**Ingleburn Resource Recovery Facility (SSD 8593)
Response to Submissions**

Attachment 1: Additional Information

- NOTES
1. All trucks arriving on site must adhere to the existing BRS procedure titled "Traffic Stacking and Queuing Procedure" as updated from time to time,

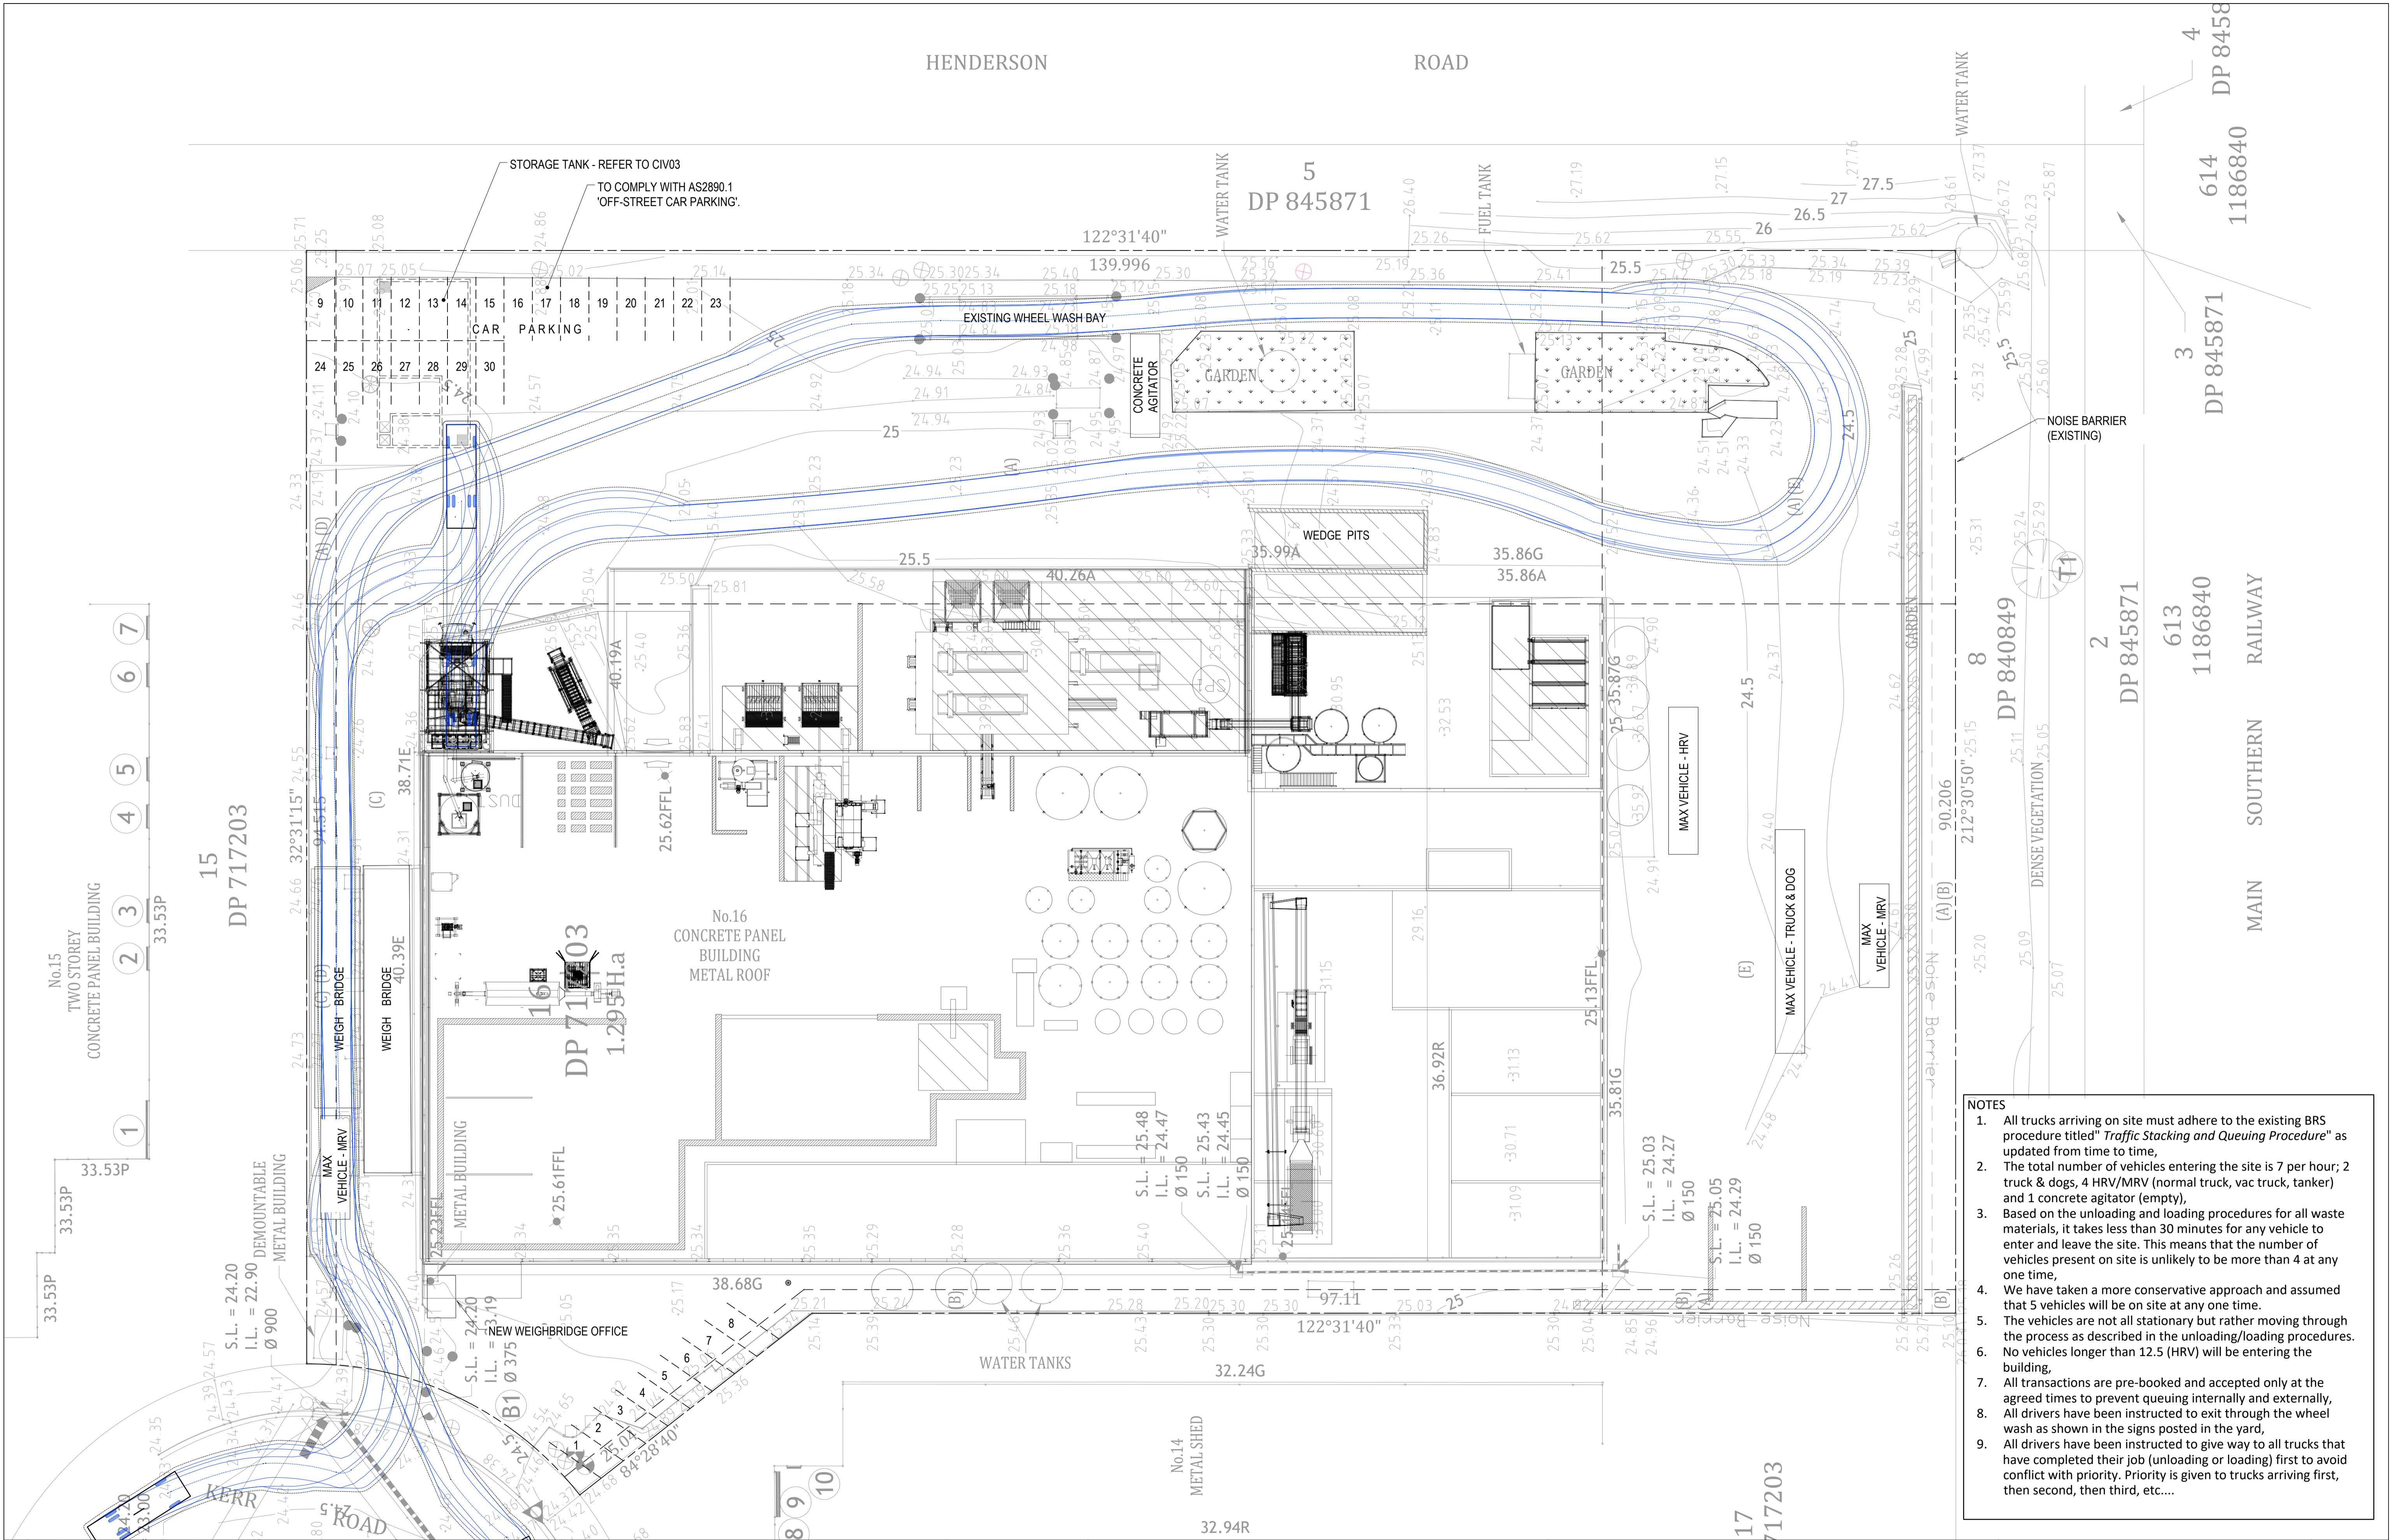
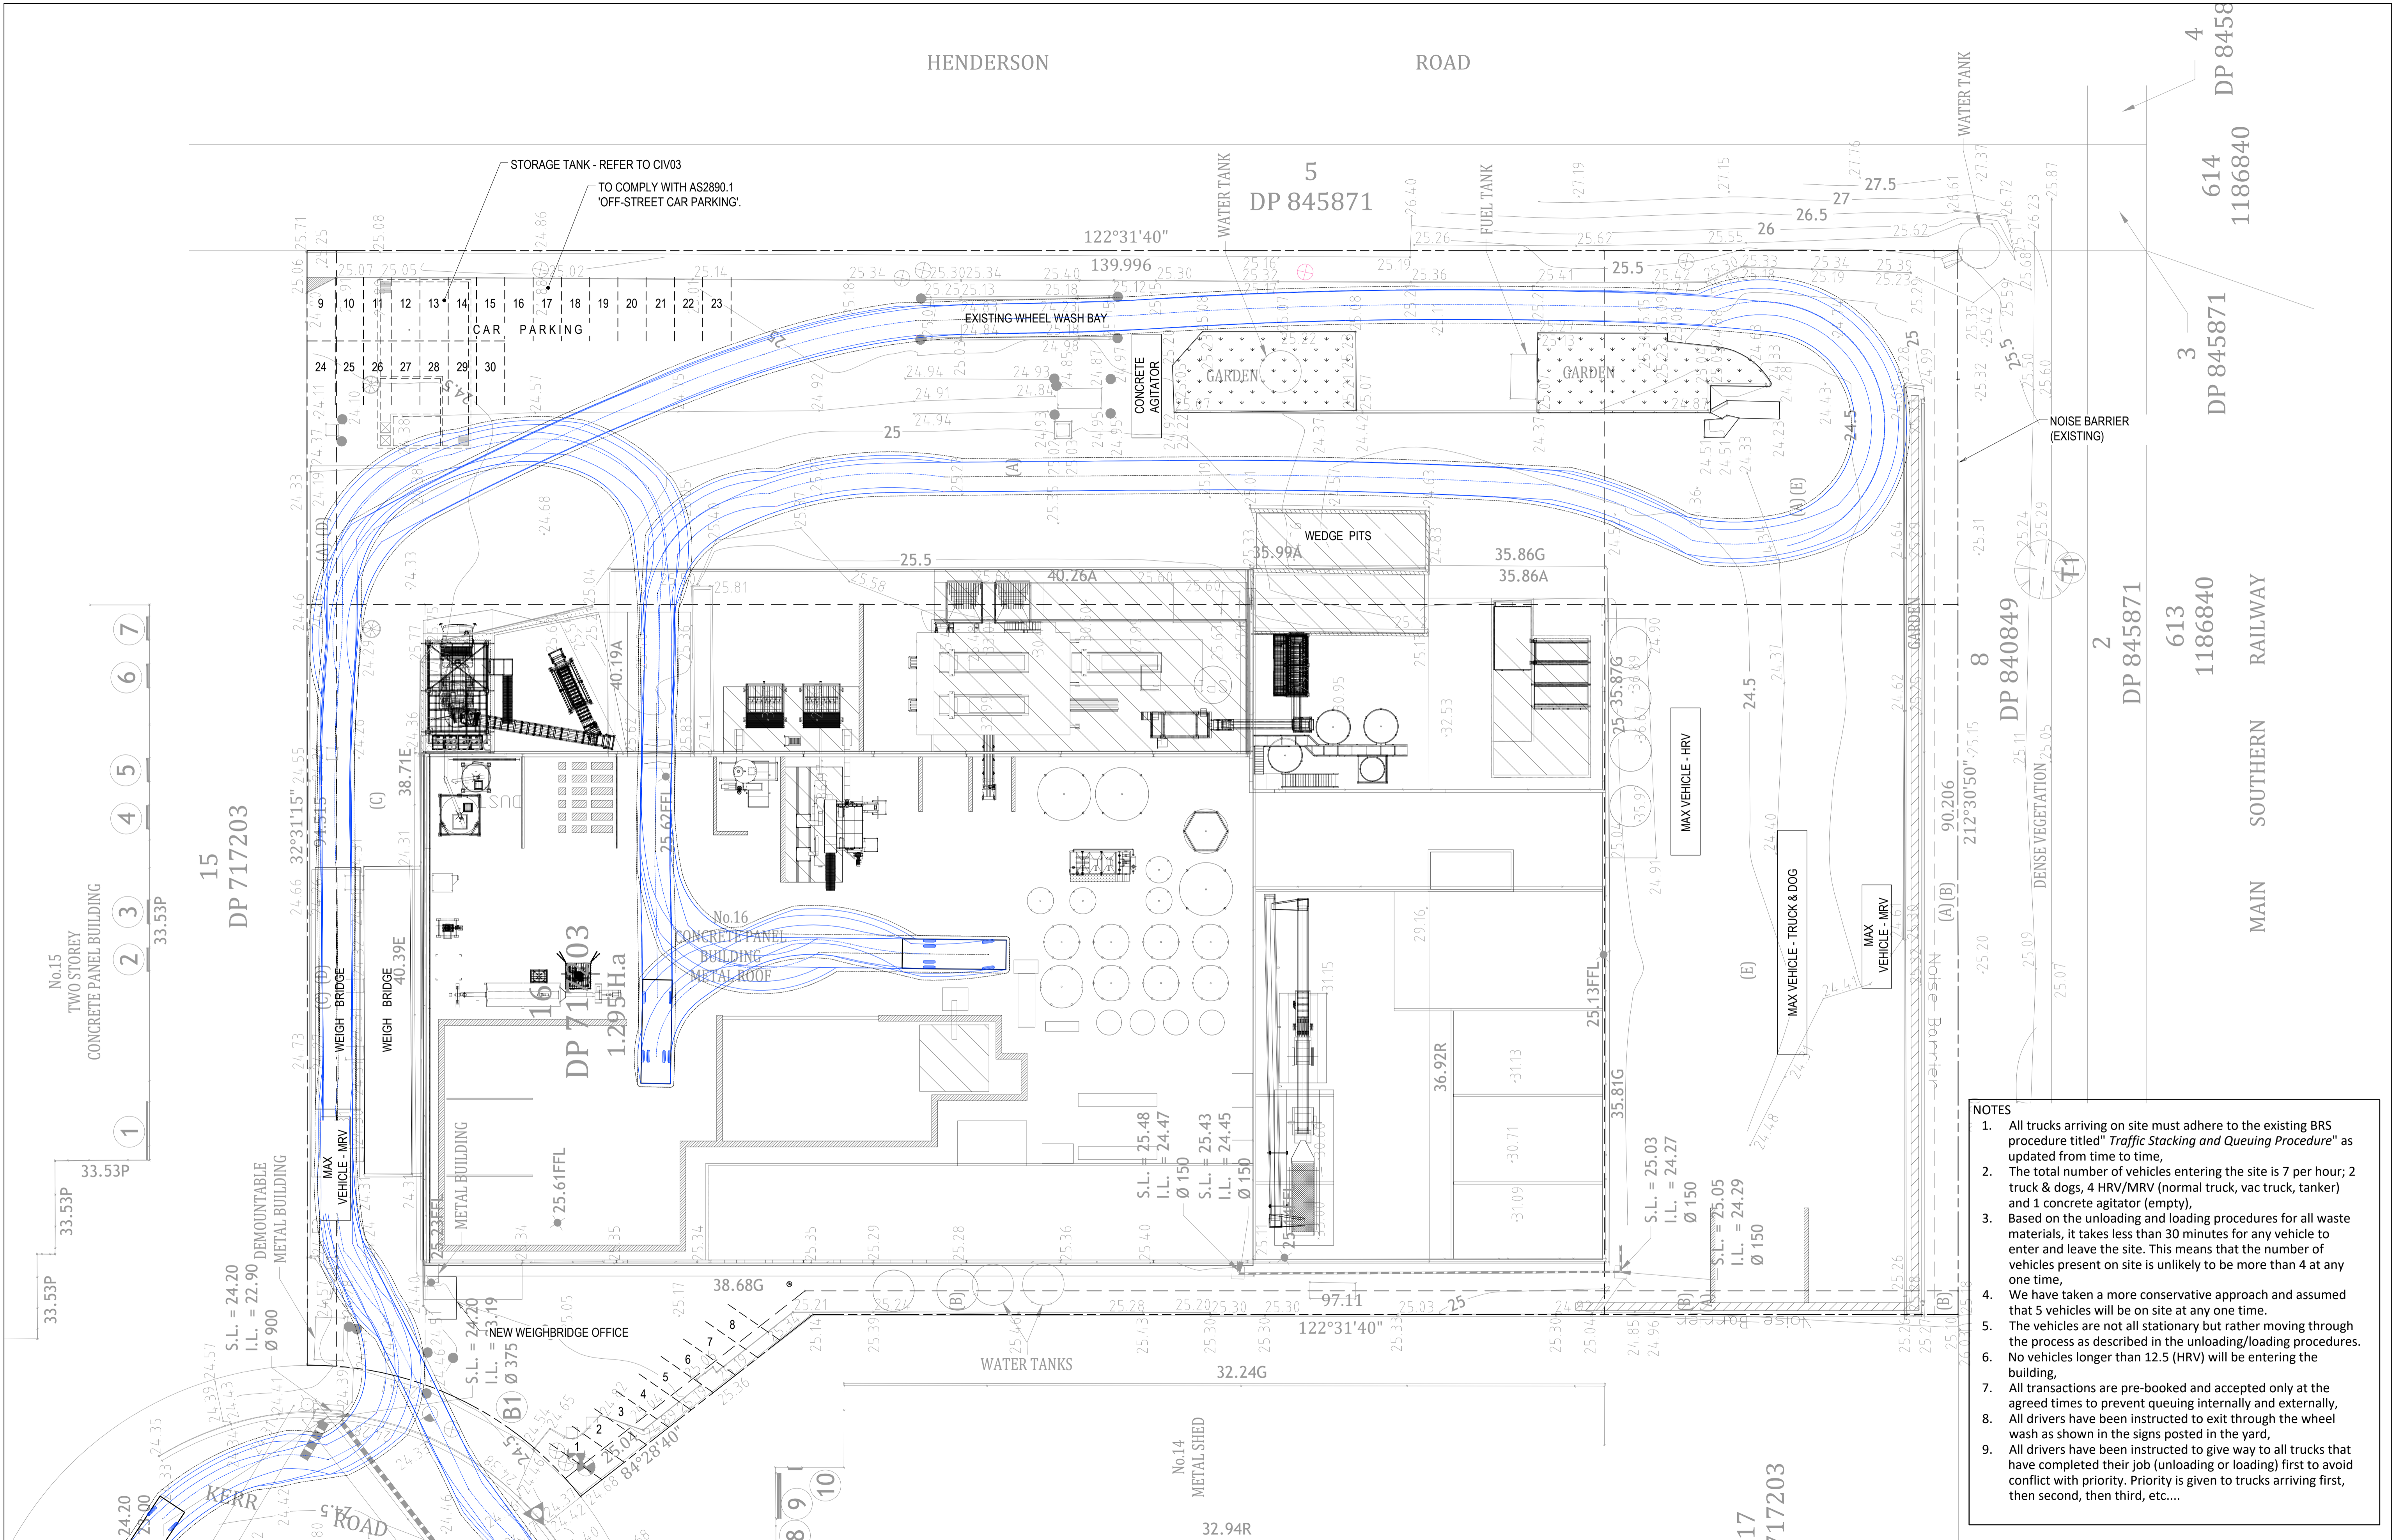
- The temporary storage area (solid materials, skip bins and solids for transfers) and staff parking area appears to be located in the heavy vehicle turning path for B double, articulated vehicle paths and mud waste and smaller trucks. Provide details on how heavy vehicle will be managed and updated plans that show that heavy vehicle safely manoeuvre within the site and the relocation of the receivals area.

- The parking bays appear to be in very close proximity to the vehicle turning path for the concrete agitator. Provide details of how heavy vehicles can safely manoeuvre within the site and not conflict with staff parking.

- The TIA does not assess onsite manoeuvring provide turning path diagrams of all on-site truck manoeuvring is required including:
 - accessing and loading and unloading all stockpiles on the site

- Front end loaders manoeuvring in and out of the building through the roller doors
 - truck manoeuvring in and out of the "loading" area at the eastern corner of the site

- trucks manoeuvring in the south-east side of the building
 - trucks manoeuvring in and out of the Concrete plant area and still allow trucks to enter the shed
